KITTITAS COUNTY
DEPARTMENT OF PUBLIC WORKS

MEMORANDUM

TO: All Staff
FROM: Public Works Plan Review Team
DATE: January 26, 2023
SUBJECT: SP-22-00005 Johnson-Duvall

JOHNSON-DUVALL SHORT PLAT
 PART OF SECTION 25, T. 18 N., R. 18 E., W.M.
 KITTITAS COUNTY, WASHINGTON

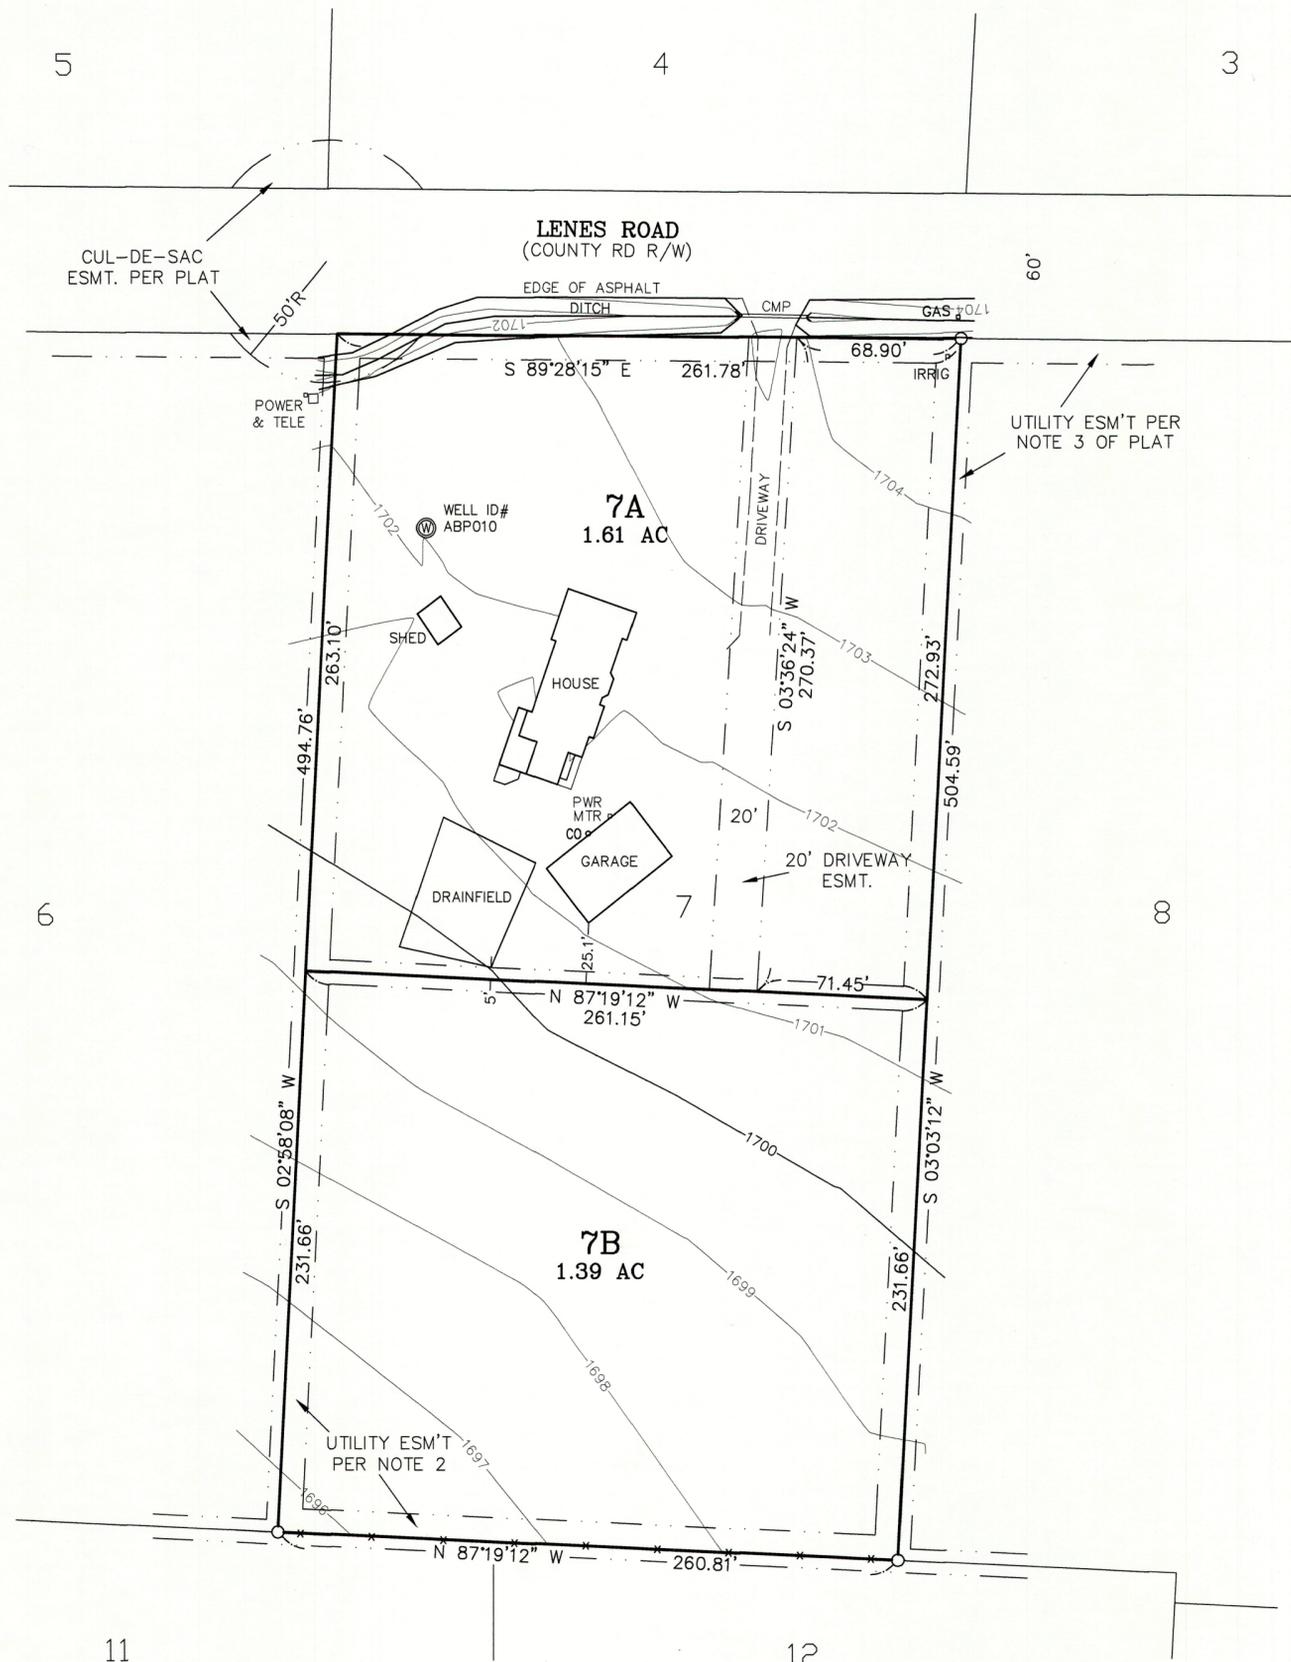
SURVEY	<ol style="list-style-type: none"> 1. Preliminary Short Plat does not meet the requirements of WAC 332-130-145 Topo Elements on Maps. 2. Prior to final approval, property corners will need to be shown on the new division line.
FLOOD	No comments (SC)
WATER MITIGATION/ METERING	<p>For the proposed short plat, the applicant must provide legal water availability for all new uses on the proposed lots of this project, which can be provided through mitigation certificates. Prior to final plat approval and recording, the following conditions shall be met:</p> <p>In accordance with KCC Chapter 13.35.027, the applicant shall provide one of the following documents before final plat approval:</p> <ol style="list-style-type: none"> 1. A letter from a water purveyor stating that the purveyor has adequate water rights and will provide the necessary water for the new use; 2. An adequate water right for the proposed new use; or 3. A certificate of water budget neutrality from the Department of Ecology or other adequate interest in water rights from a water bank. <p>All applicants for land divisions shall also submit information on "proximate parcels" held in "common ownership" as those terms are defined in WAC 173-539A-030 and otherwise demonstrate how the proposed new use will not violate RCW 90.44.050 as currently existing or hereafter amended.</p> <p>Failure to obtain mitigation before commencement of an activity requiring mitigation shall be a code violation subject to enforcement under Title 18 KCC.</p> <p>Final Plat Notes</p> <p>The following notes shall be placed on the face of the plat:</p> <p>C-1 “Metering is required for all new uses of domestic water for residential well connections and usage must be recorded in a manner consistent with Kittitas County Code Chapter 13.35.027 and Ecology regulations.”</p> <p>C-2 “The approval of this division of land provides no guarantee that use of water under the ground water exemption (RCW 90.44.050) for this plat or any portion thereof will not be subject to curtailment by the Department of Ecology or a court of law.”</p>
